# SUNNICA ENERGY FARM

EN010106

8.63 Applicant's Response to Other Parties' Deadline 2, 3 and 3A  
Submissions

<b>Planning Inspectorate Scheme Reference</b>	EN010106
<b>Application Document Reference</b>	EN010106/APP/8.63
<b>Author</b>	Sunnica Energy Farm Project Team

**APPENDIX 3**  
**DIMENSIONS OF RIGHTS BEING**  
**REQUESTED**

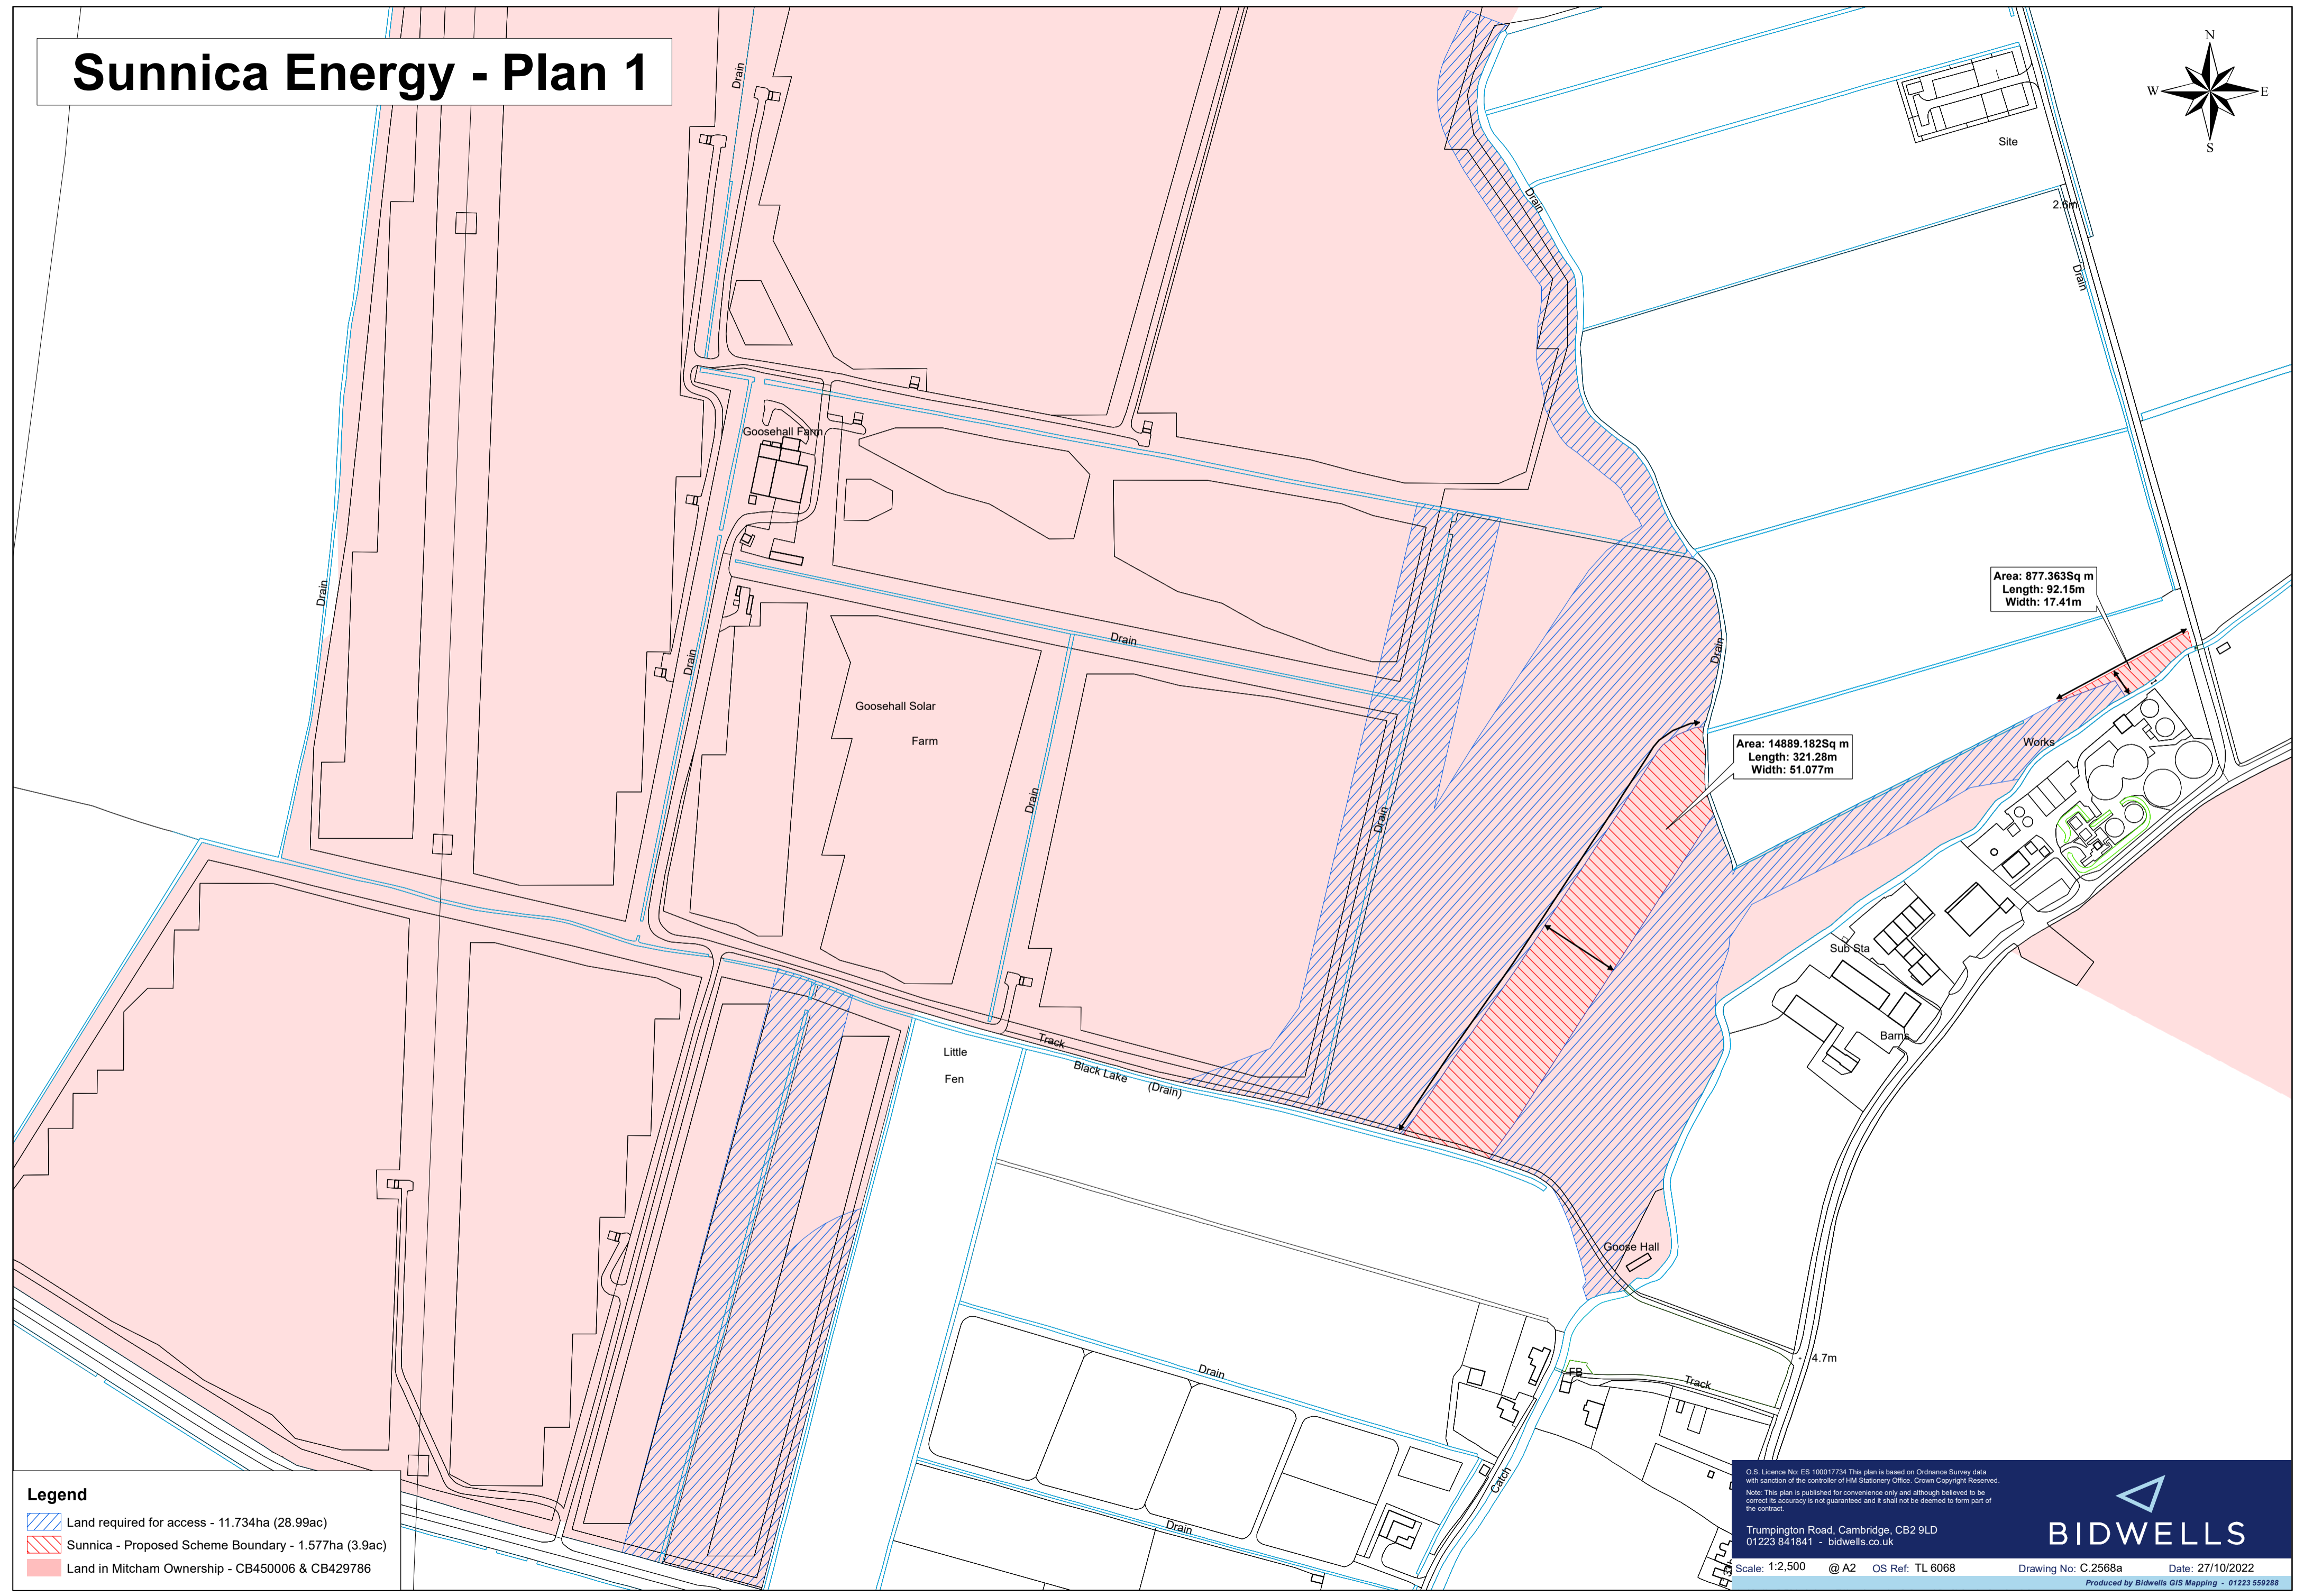
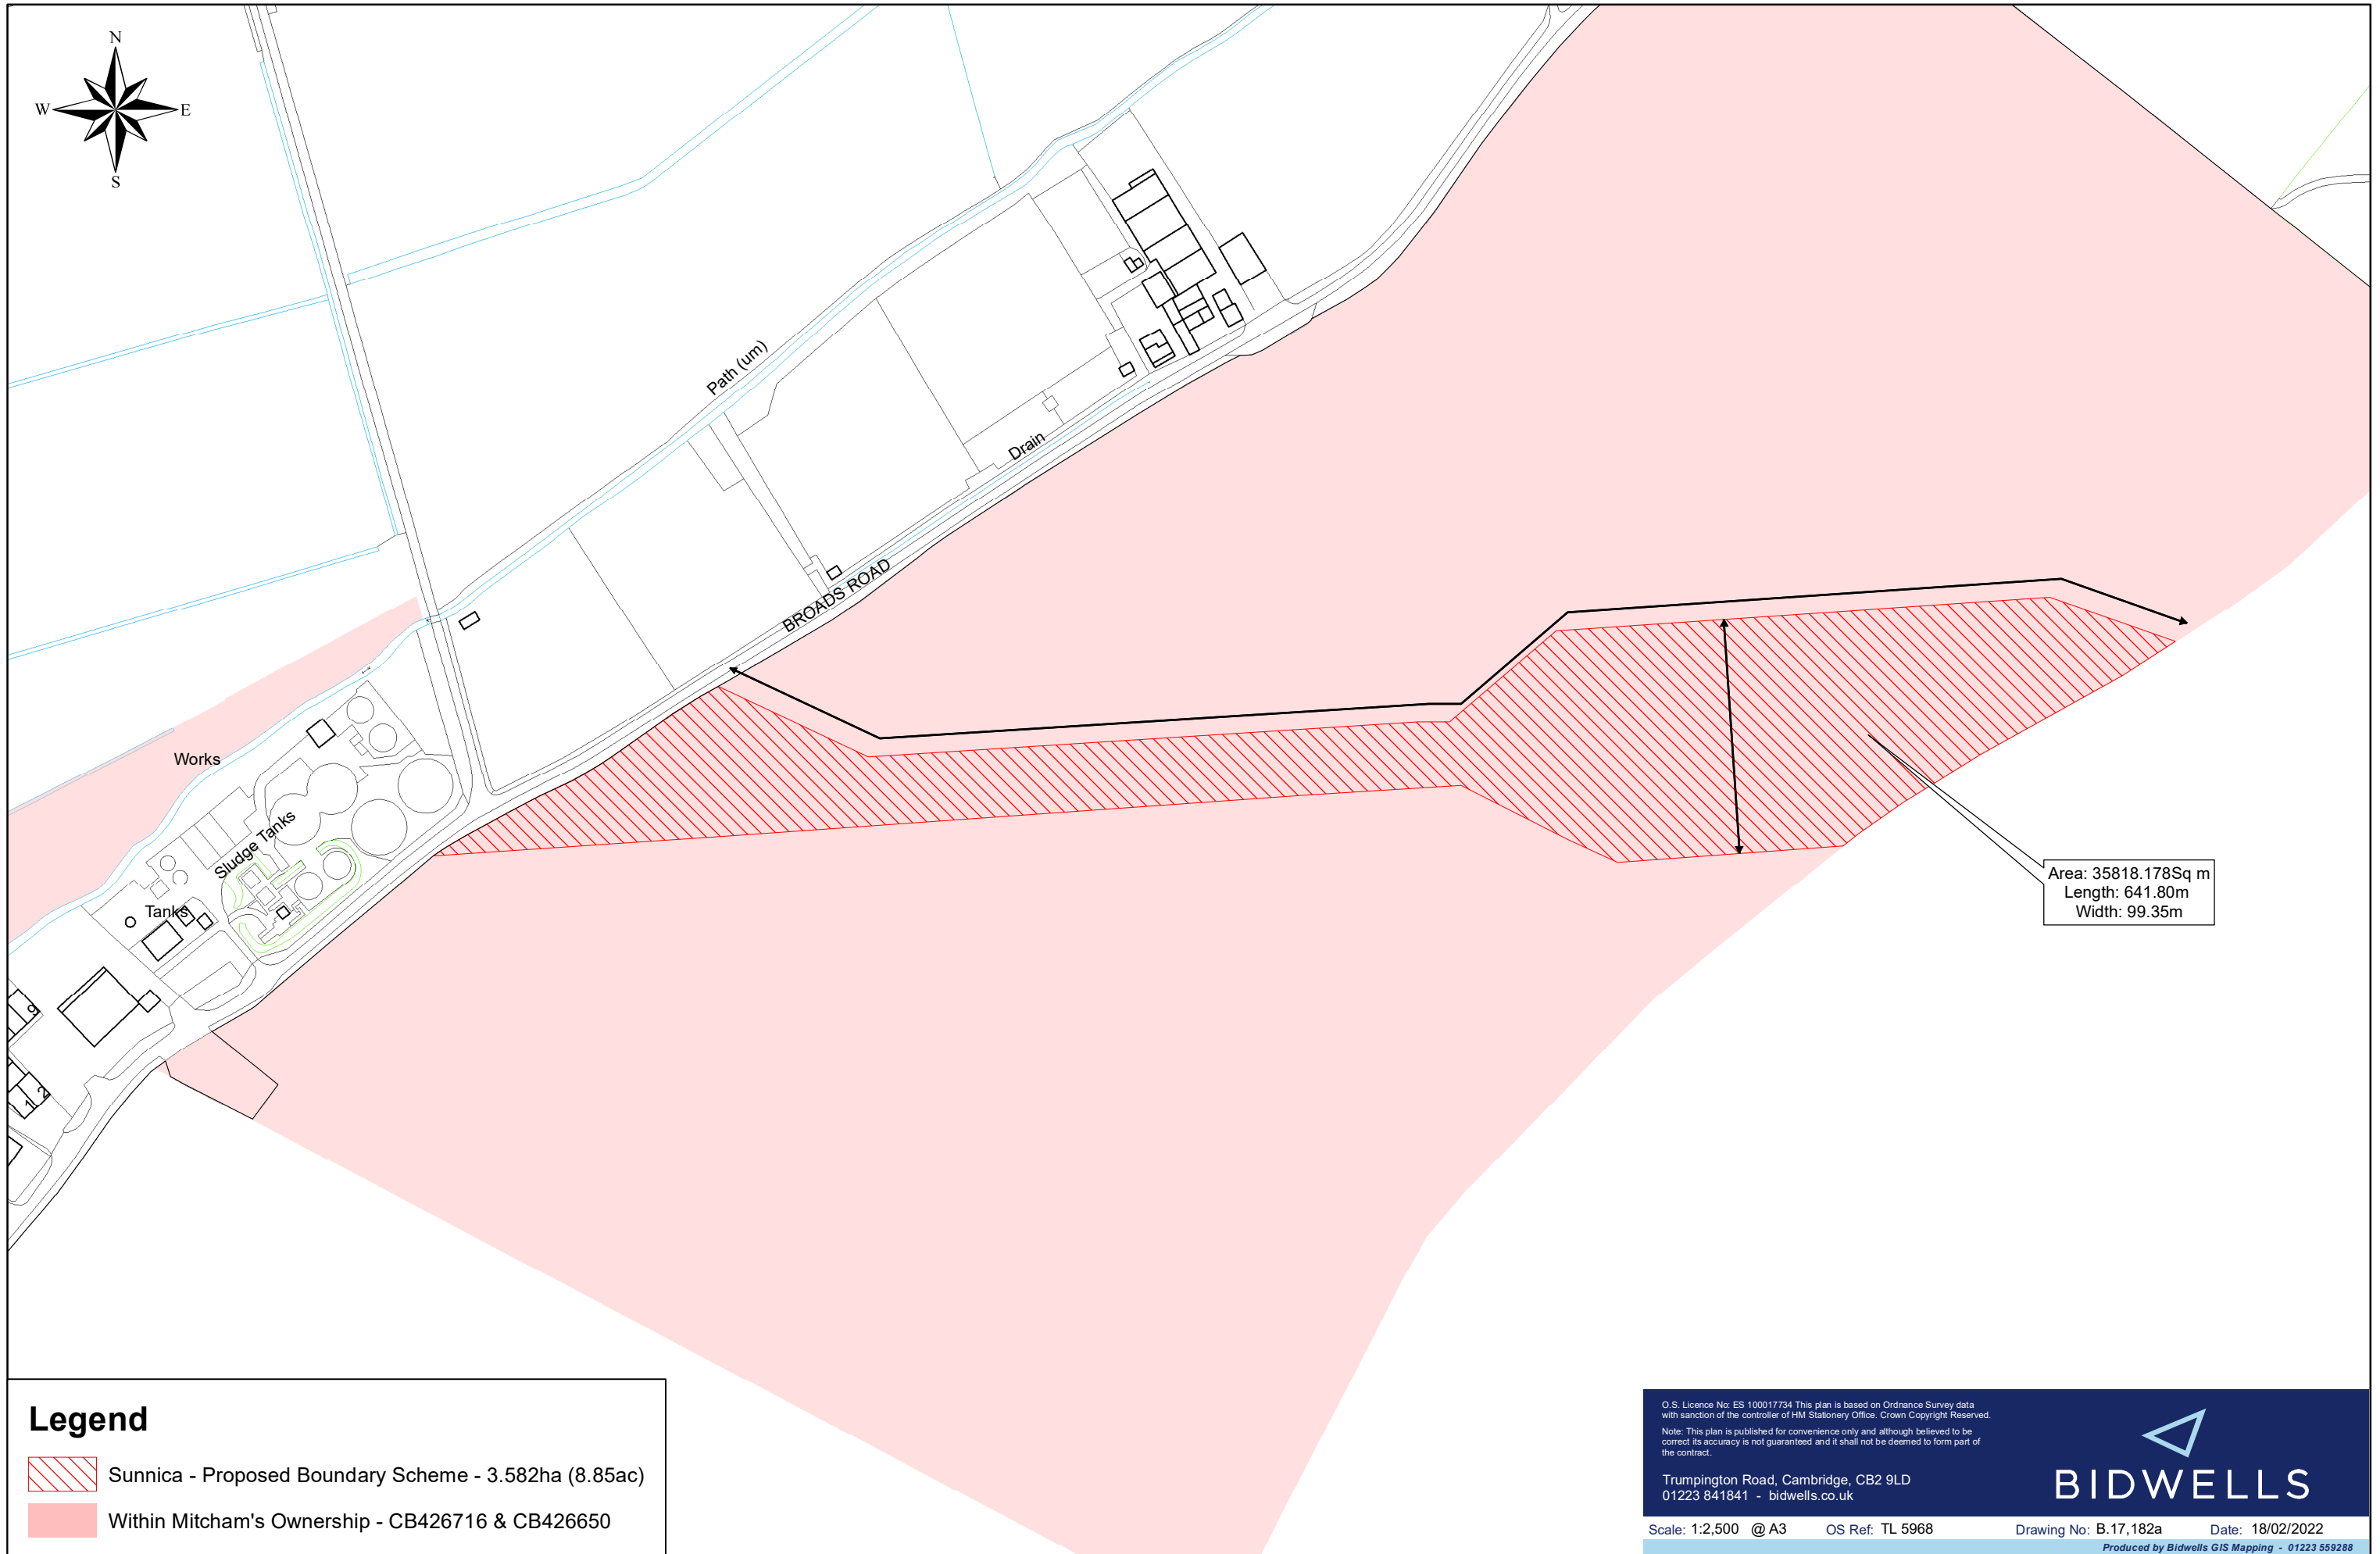
Party name	Theme	Summary of issue raised	Applicant's response		
	Area of Rights Acquired	<p>The discrepancy between the area Sunnica require for an easement, and the land they are trying to acquire powers over, must be resolved.</p> <p>A particular area of concern for the Mitcham family is Fordham House, where the proposed easement is 55m wide. Not only is this excessive, but on a review by our mapping team, it would appear the plans included within the DCO are actually over 65m wide (Appendix 3).</p> <p>Bidwells are involved in the North Sea wind farm cables, acting for impacted landowners. These cables carry 1.4GW of energy. Easements of maximum 20m are being agreed. It is hard to understand why Sunnica require such wide areas.</p> <p>The Mitcham family is content with the principle of a 10m wide easement and a reasonable working area around this, as appropriate for the maximum 132kV cable. However, the significant areas enclosed within the scheme boundary and the discrepancy between areas actually needed versus included is not reasonable.</p>	<p>Appendix A of the Statement of Reasons explains the requirements for additional widths in the land where rights are being acquired on the cable corridor. The land requirements on the Land Plans have been drawn up in line with the explanation provided in that Appendix and the consequential limits of deviation shown on the Works Plans. It is not intended that the final easement itself would be of a width of 55m, but powers are required over that area to deal with the constraints on the Mitcham Family land. Constraints affecting the Mitcham Family plots are set out below:</p>

<b>Plot</b>	<b>RLB Width</b>	<b>Rationale</b>
			19-03	50m	<p>A working width of up to 50m is required for constrained land. The additional width, beyond the 30m identified for unconstrained land is required due to a specific constraint or potential combination of constraints that have been identified following survey works that were undertaken. These constraints typically result in challenging engineering works/solutions that fall within one of the following categories:</p> <p>Access Issues: There are sections of the Sunnica route where site access onto the cable route corridor from either the public highway or onto the cable route corridor from internal roads or tracks is extremely limited. This means that plant machinery and materials will need to travel along sections of the cable route corridor in order to reach the work site. As such, a wider construction width is required at these locations to provide lateral separation between transport movements and ongoing excavation and cable laying works. Additional space will also be required for the stockpiling of both materials and spoil.</p> <p>Horizontal Directional Drilling (HDD) Required:</p>

Party name	Theme	Summary of issue raised	Applicant's response		
					<p>A number of sections requiring HDD have been identified during survey works. An increased construction width is required at these locations for reasons that include a. To allow spacing of the bores; b. To allow for the excavation of the launch and receive pits; Sunnica Energy Farm Statement of Reasons Planning Inspectorate Scheme Ref: EN010106 Application Document Ref: EN010106/APP/4.1 Page 76 c. To allow space for the additional heavy plant required; d. To allow space for the materials required at hand (e.g., water tanks, bentonite, duct); or e. To allow for the safe movement and turning of vehicles</p>
			18-18	<20m	<p>Directional drilling will be required in order to cross drainage and field boundaries. There is limited access available across this section of the cable route and in order to accommodate the necessary equipment and materials required it may be necessary to utilise part of this plot for the laying of the cable This will be determined at detailed design</p>

18-10	30m / 100m	<p>Directional drilling will be required in order to cross drainage and field boundaries. There is limited access available across this section of the cable route and in order to accommodate the necessary equipment and materials required, a wider cable route corridor width of circa 100m is necessary.</p>
			18-09	100m	<p>The corridor width has been widened in this location as geophysical survey was incomplete and adequate space is required to allow micro siting of the cable at the detailed design stage. In addition, there are challenges crossing the two gas pipes either side of Ness Road</p>

Party name	Theme	Summary of issue raised	Applicant's response		
			18-01	70m	The geophysical survey identified potential archaeological features within plot 18-01, therefore the cable width is required in order to microsite the cable during detailed design. In addition, there are challenges crossing the two gas pipes either side of Ness Road
			17-03	35m / 70m	The geophysical survey identified potential archaeological features within plot 17-03, adjacent to Plot 18-01, therefore the cable width is required in order to microsite the cable during detailed design. Narrow to follow the track as far as possible and minimise the impact on the extent of the proposed Breach Solar Farm. There are challenges crossing the two gas pipes either side of Ness Road
			16-14	60m	<p>Network Rail crossing and Specific pinch point</p> <p>This section of the route is subject to a number of constraints and engineering challenges.</p> <ul style="list-style-type: none"> <li>i. Directional drilling will be required to pass beneath the A142 and the adjacent railway line;</li> <li>ii. There is limited access for labour, plant and materials throughout this section; Up to circa 100m wide Sunnica Energy Farm Statement of Reasons Planning Inspectorate Scheme Ref: EN010106 Application Document Ref: EN010106/APP/4.1 Page 77</li> <li>iii. A requirement to cross an existing high pressure gas main running approximately north – south in the vicinity of Newmarket Road;</li> </ul>

Party name	Theme	Summary of issue raised	Applicant's response	
				<ul style="list-style-type: none"> <li>iv. There are significant areas of potential archaeological interest located on each side of the A142 / rail crossing;</li> <li>v. Significant alignment changes are required in both plan and section. The combination of constraints across this section means that an increased corridor width of circa 100m will need to be retained in order to complete the works</li> </ul>
			<p>Regarding the land at Fordham House this is an area where HDD will be required in order to route the cable underneath the adjoining A142 and the railway. An increased construction width is required for reasons that include allowing the spacing of the bores, to allow for excavation of the launch and receive pits, to allow space for the additional heavy plant required, to allow space for the materials required at hand, to allow for the safe movement and turning of vehicles.</p> <p>The exact width of permanent easement required is not yet known in this location as detailed design has not taken place.</p>
